From: Sarah Burrow <Sarah.Burrow@arun.gov.uk>
Sent: 18 May 2021 09:53
To: Planning.Responses <Planning.Responses@arun.gov.uk>
Cc: Anita Gardner <Anita.Gardner@arun.gov.uk>
Subject: RE: Planning Consultation on: FG/46/21/PL

Engineers Comments Regarding Surface Water Drainage

Application No: FG/46/21/PL
Registered: 24th March 2021
Site Address: Land between 11a The Grove and 30 Brook Lane Ferring
Grid Reference: 508122 45122
Description of Works: Development of 1 2 bed house set over 2 floors, with first floor being partially contained within roof, along with associated parking & amenity spaces. This site is within CIL Zone 4 and is CIL liable as new dwelling.

Drawing Title 028_02 Proposed Ground Floor Plan Land between 11A The Grove and 30 Brook Lane, Ferring					
Completion date 17/03/2021					
Drawn by Guy Rochez ARB					
Scale: 1:100@A3					
Print Size: A3					
Notes:

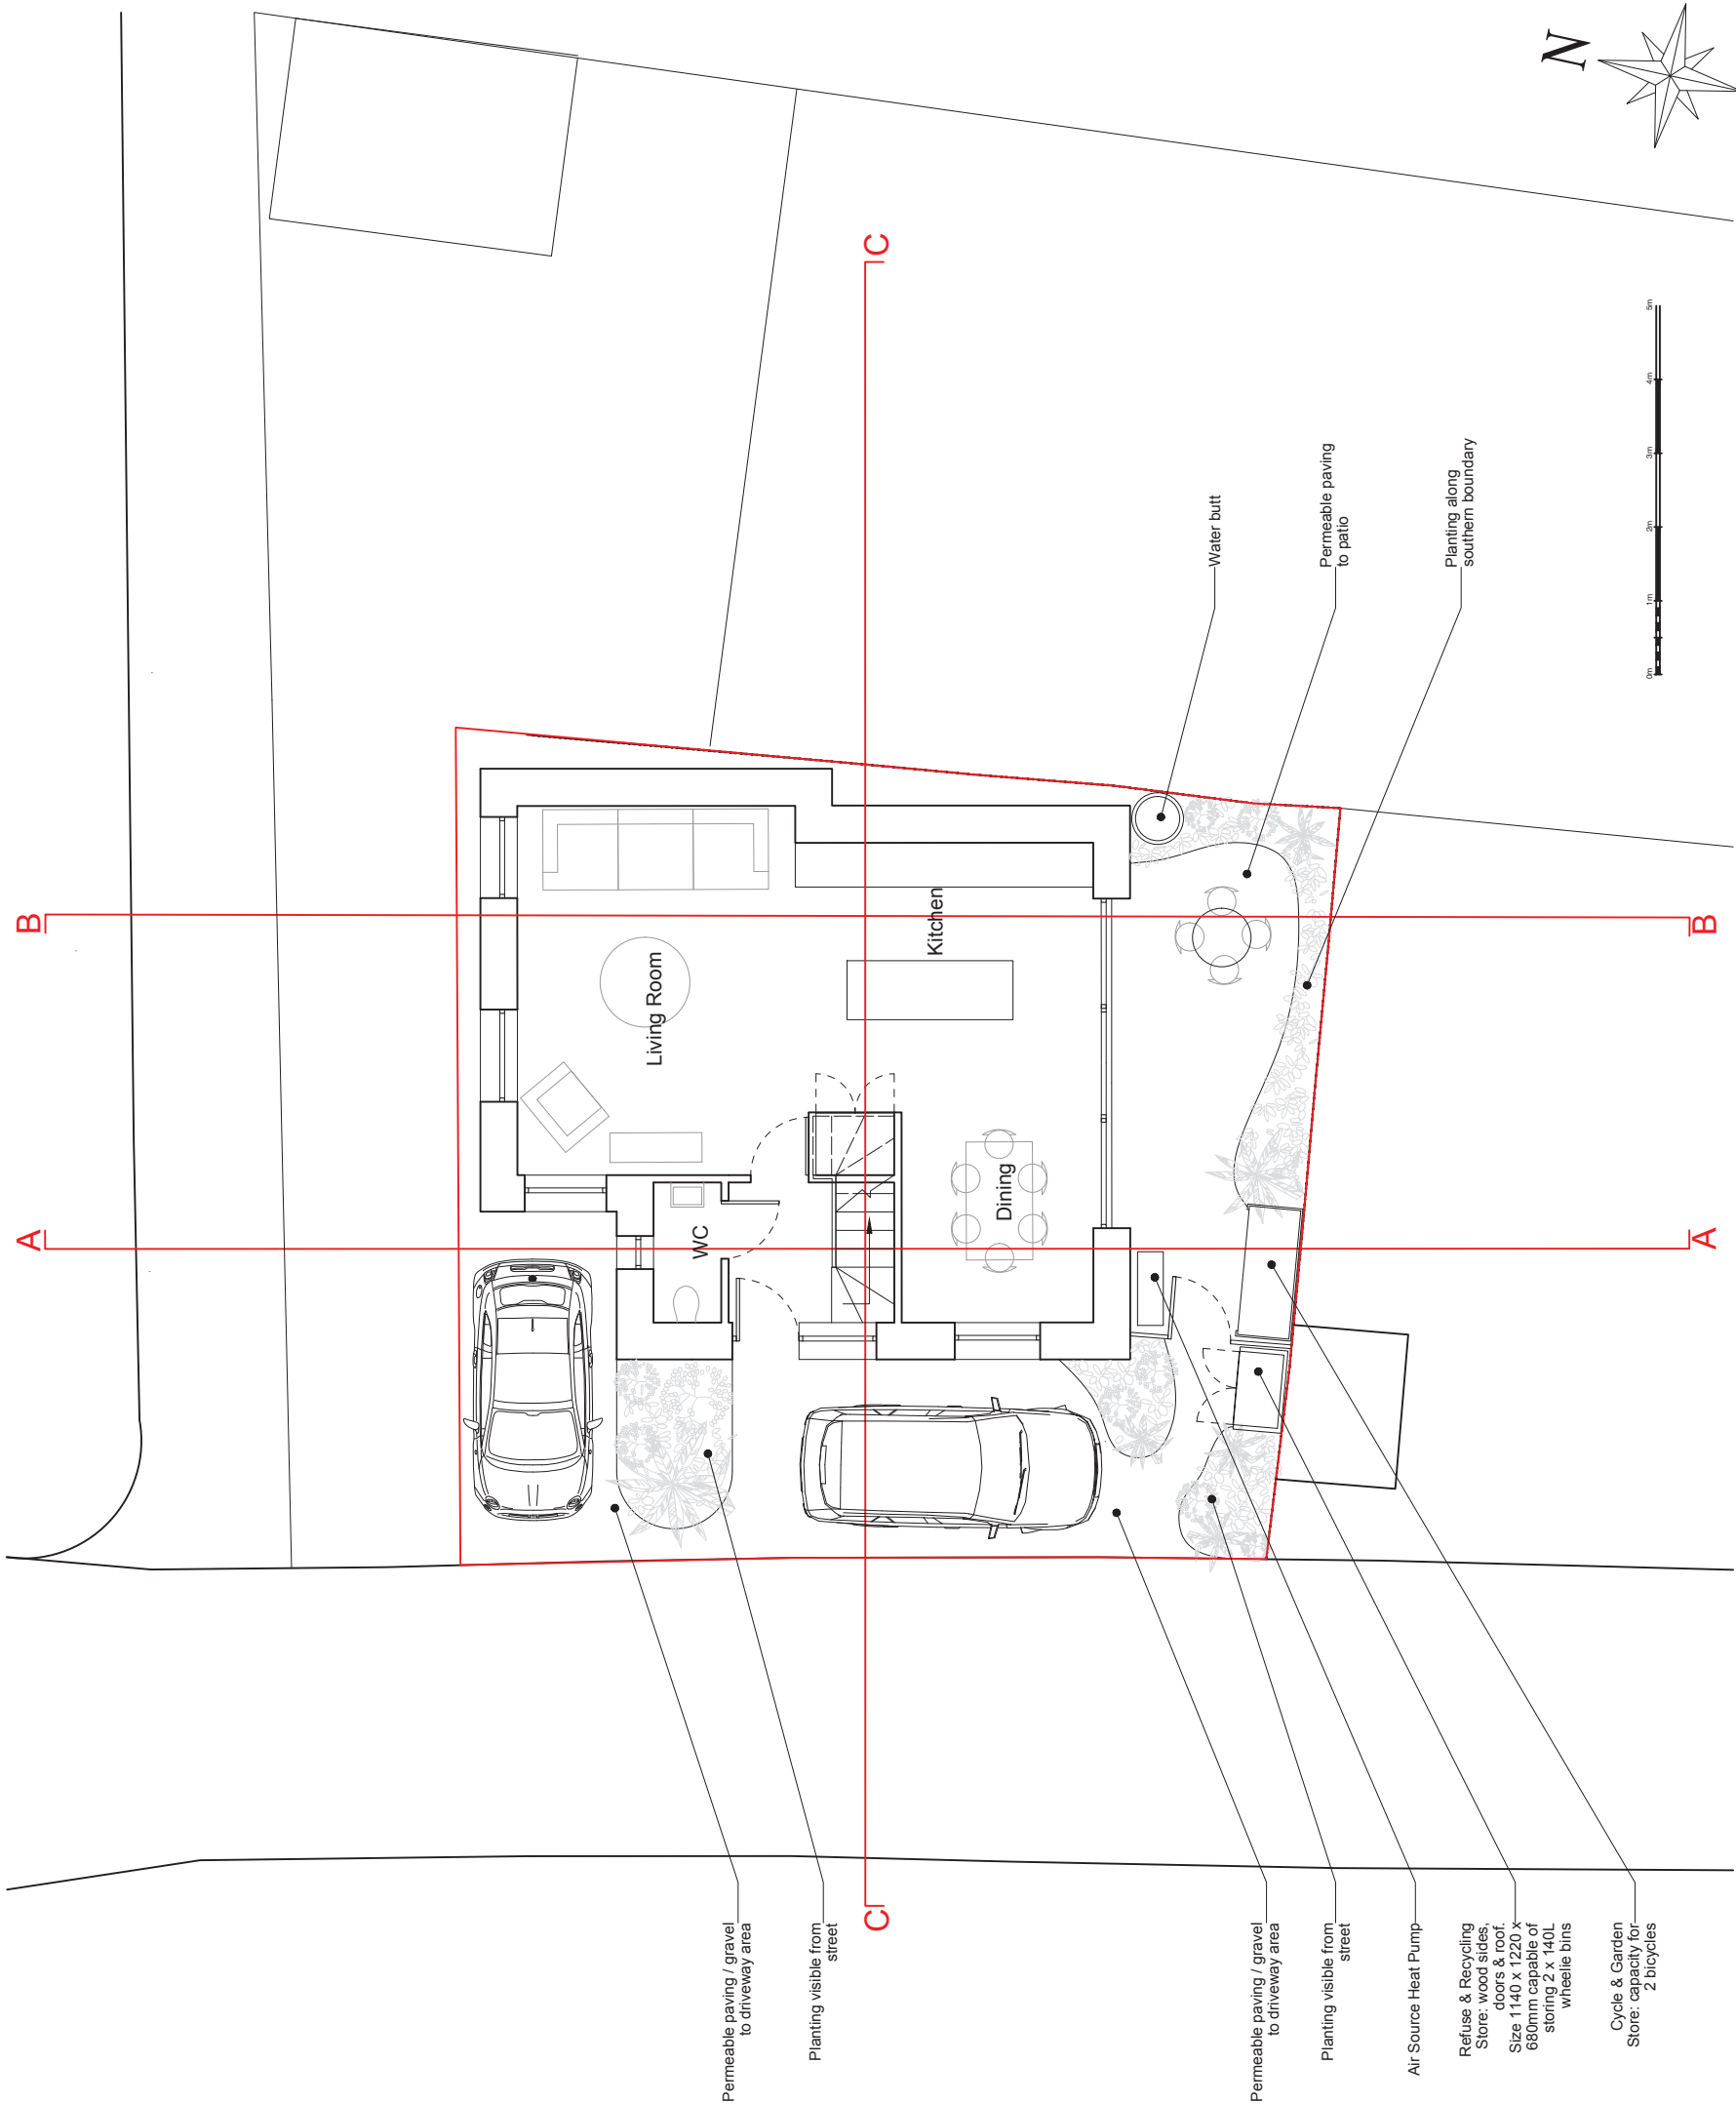
I would like it noted that we would have objected to the application on the grounds of insufficient space for soakaways and the potential for the development to increase flood risk elsewhere. If the applicant is considering altering their design or reapplying then they should consult with our department about the easements required for soakaways as lack of space is an insufficient excuse for not following the hierarchy for sustainable drainage.
